WEST SUSSEX COUNTY COUNCIL CONSULTATION

TO:	Arun District Council FAO: Simon Davis
FROM:	WSCC - Highways Authority
DATE:	11 October 2021
LOCATION:	75 Highfield Road, Bognor Regis, PO22 8PD
SUBJECT:	BR/222/21/PL Creation of 1 No 1 Bed & 1 No 2 bed Units to roof space of existing block with 2 No new car parking space and revised access provision. This site is in CIL Zone 4 (Zero Rated) as flats.
DATE OF SITE VISIT:	N/A
RECOMMENDATION:	Advice
S106 CONTRIBUTION TOTAL:	N/A

Site Plan (Proposed) 1:200

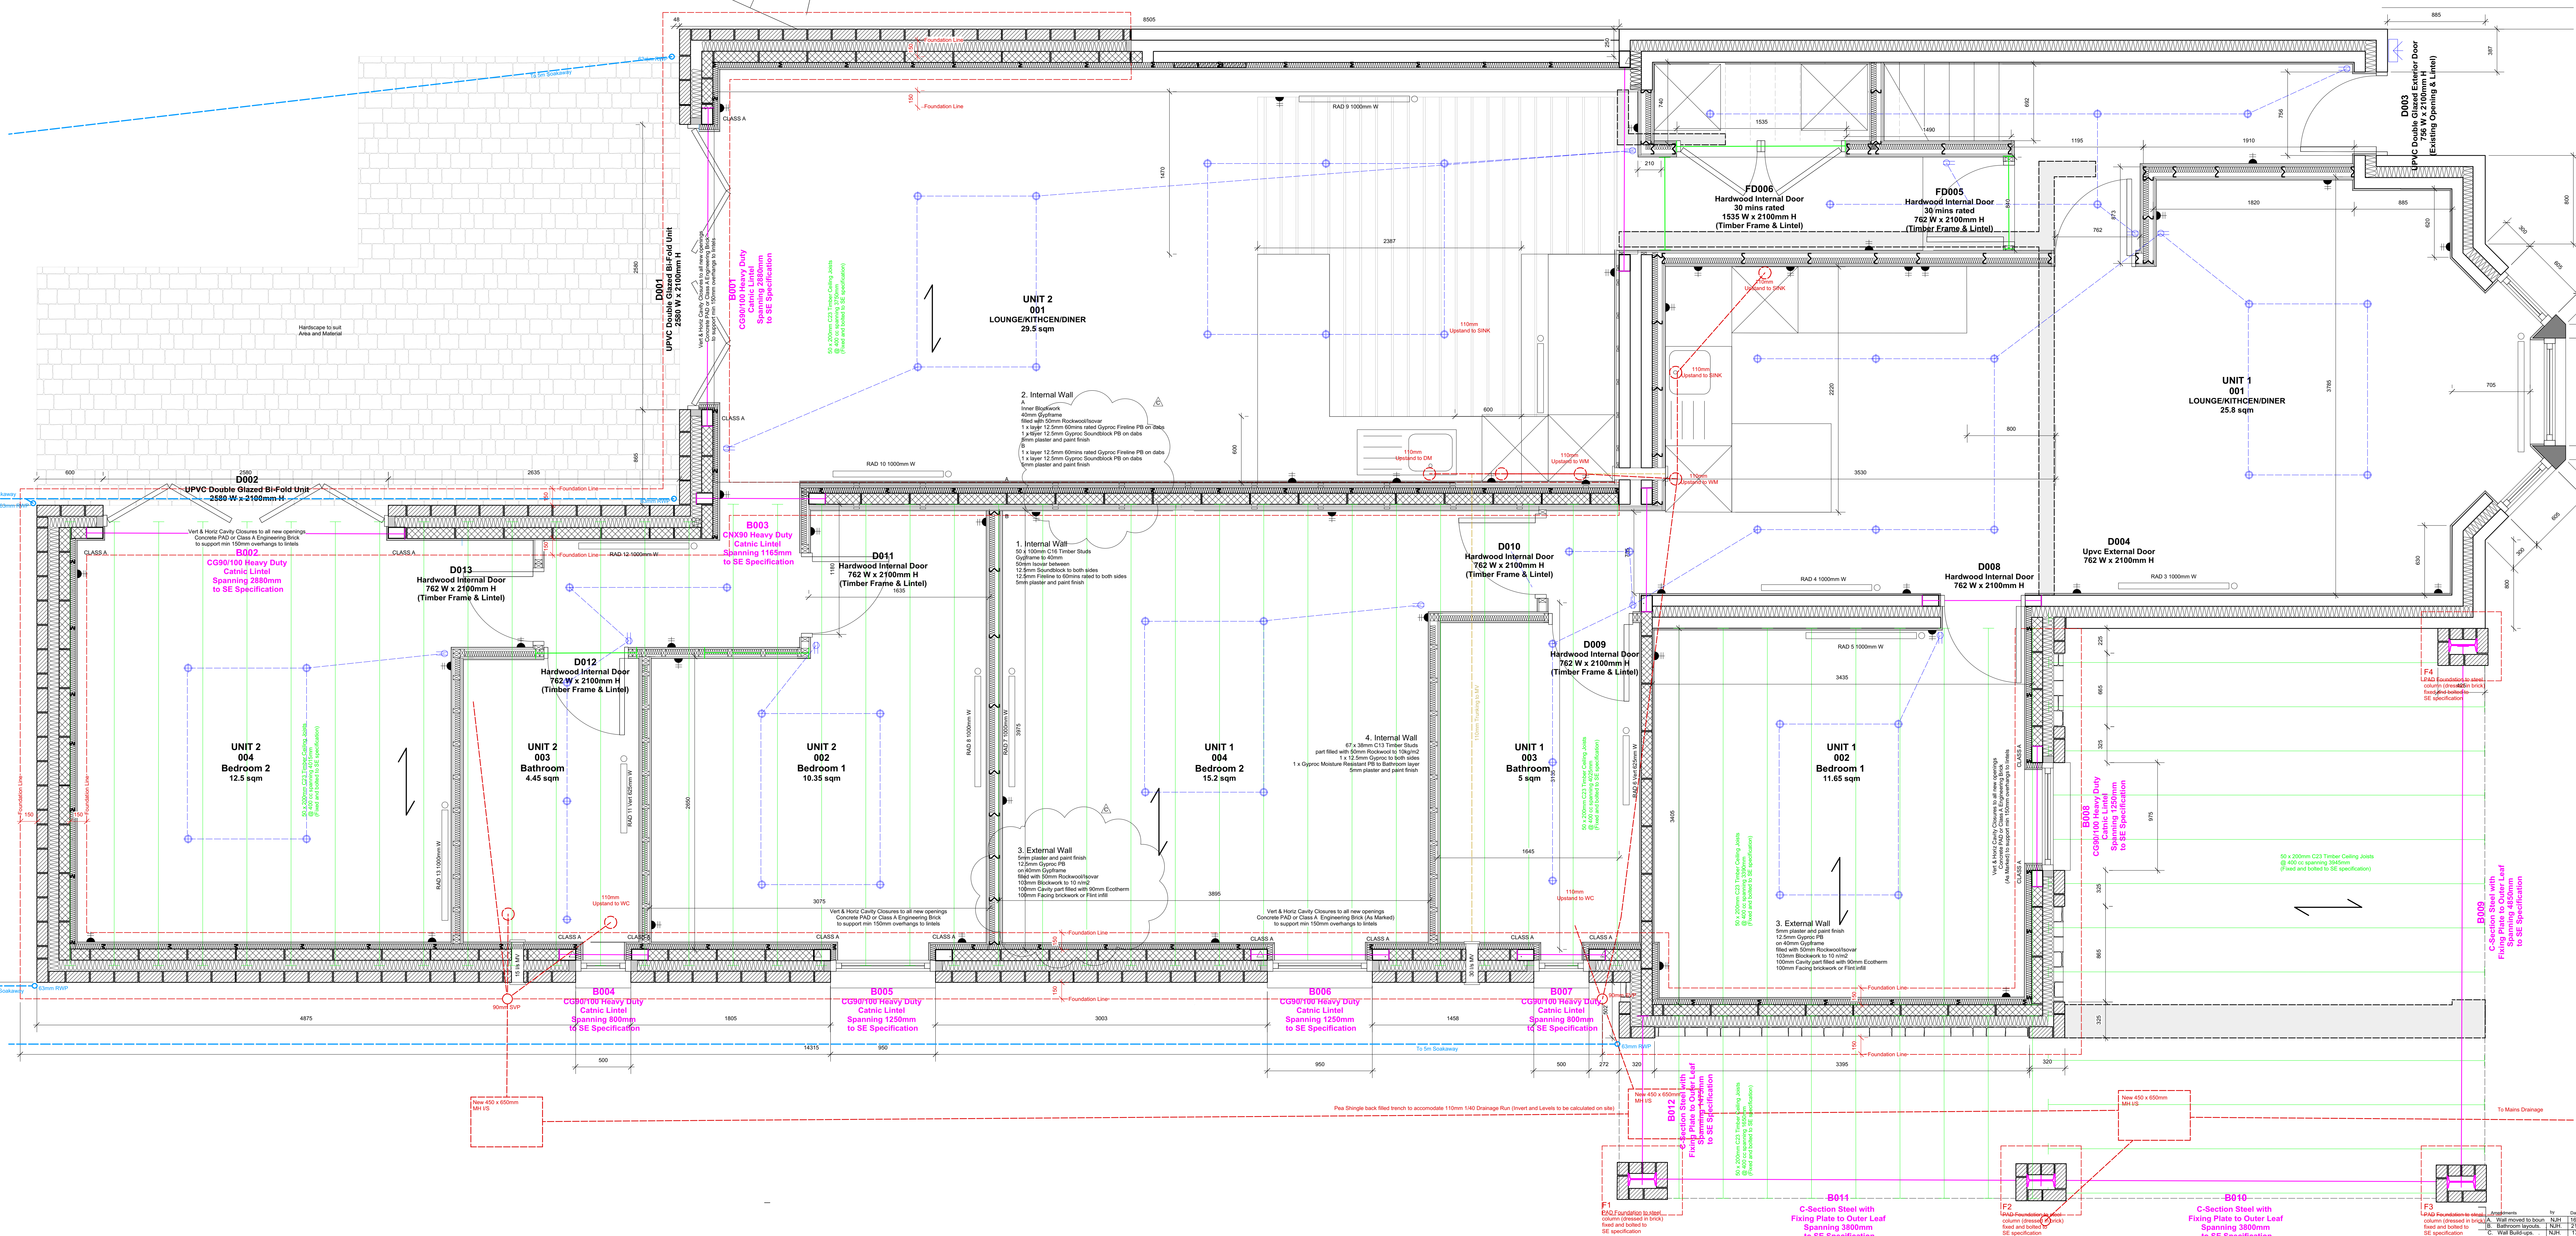
The applicant proposes to utilise an existing vehicle crossover (VCO) for this application. From inspection of local mapping, there are no apparent visibility issues with the existing point of access on to Highfield Road. The LHA does not anticipate that the proposal would give rise to a significant material intensification of movements to or from the site.

The applicant has stated that an existing utility pole will be relocated as part of these proposals. These relocation works would need to be undertaken at the expense of the applicant. It is the responsibility of the applicant to liaise with the necessary parties to organise the moving of the utility pole.

The applicant proposes four car parking spaces for this development. From inspection of the plans, the parking bays are suitably sized. On-site turning appears achievable for the parking bays situated to the rear of the site; however, cars exiting the bays fronting the site may have to do so in a reverse gear. However, the LHA does not anticipate that this would result in a highway safety concern.

Under Arun Parking Standards, the LHA would anticipate that a development of this size in this location would require at least six car parking spaces (when considering the site as a whole). Therefore, overspill parking would have to be accommodated on-street.

Whilst on-street parking is limited in the area, there are comprehensive parking restrictions in place prohibiting vehicles from parking in places that would be a detriment to highway safety. The LHA does not anticipate that a shortfall of two parking spaces would result in a highway safety concern. However, the LPA may wish to consider the potential impacts on on-street parking from an amenity point of view. The LHA acknowledges that the proposed parking provision is an improvement over the existing parking provision.

Regarding cycles, the applicant has not demonstrated cycle parking provision. Cycling is a viable option in the area and the LHA would like to see cycle parking provision being implemented, in accordance with Arun Parking Standards. A cycle parking provision for six cycles should be provided in the form of covered and lockable cycle storage.

No part of the development shall be first occupied until the car parking has been constructed in accordance with the approved site plan. These spaces shall thereafter be retained at all times for their designated purpose.

No part of the development shall be first occupied until covered and secure cycle parking spaces have been provided in accordance with plans and details to be submitted to and approved by the Local Planning Authority.
